WCC PAPER No. 3

Winchester City Councils Comments on Joint Bay Technical Note 7.9.26 (REP6-070)

The Council has reviewed the Joint Bay Technical note submitted at Deadline 6 and has a number of comments on its contents.

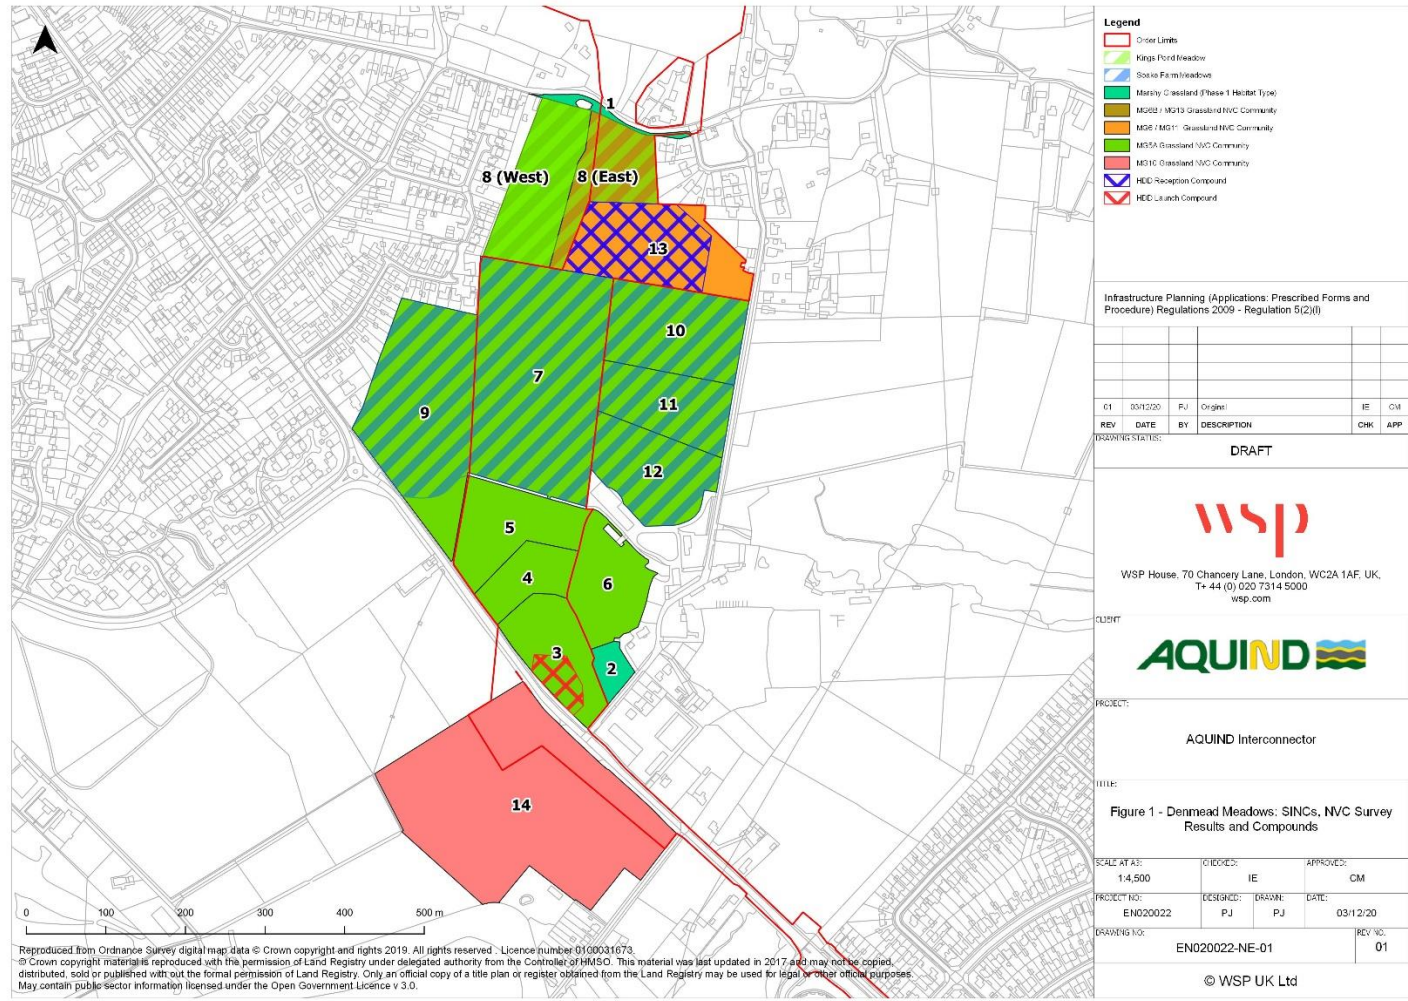
JB4 is to be located at the western end of field No 13 (see Figure 1 in the Denmead Meadows Position Paper RREP6-072) which lies at the northern end of the Denmead Meadows complex. The Council notes this will result in the permanent loss of a small area of soft ground.

JB5 is to be located on the south side of Hambledon Road opposite Soake Lane. This location is east of the field, which is identified as a potential site for the launch compound for HDD5 (field 14 on Figure 1 in the Denmead Meadows Position Paper RREP6-072). The Council has a number of questions regarding this location for the JB. There is a concern that this location for JB5 will be used to justify or support the location of the HDD5 launch compound to be positioned on the north side of the road in field 3 ((see Figure 1 in the Denmead Meadows Position Paper RREP6-072). The ExA will recall from other representations made by the Council that it supports the location for the launch compound on the south side of the road (field 14). It is considered that the following would help to facilitate that outcome.
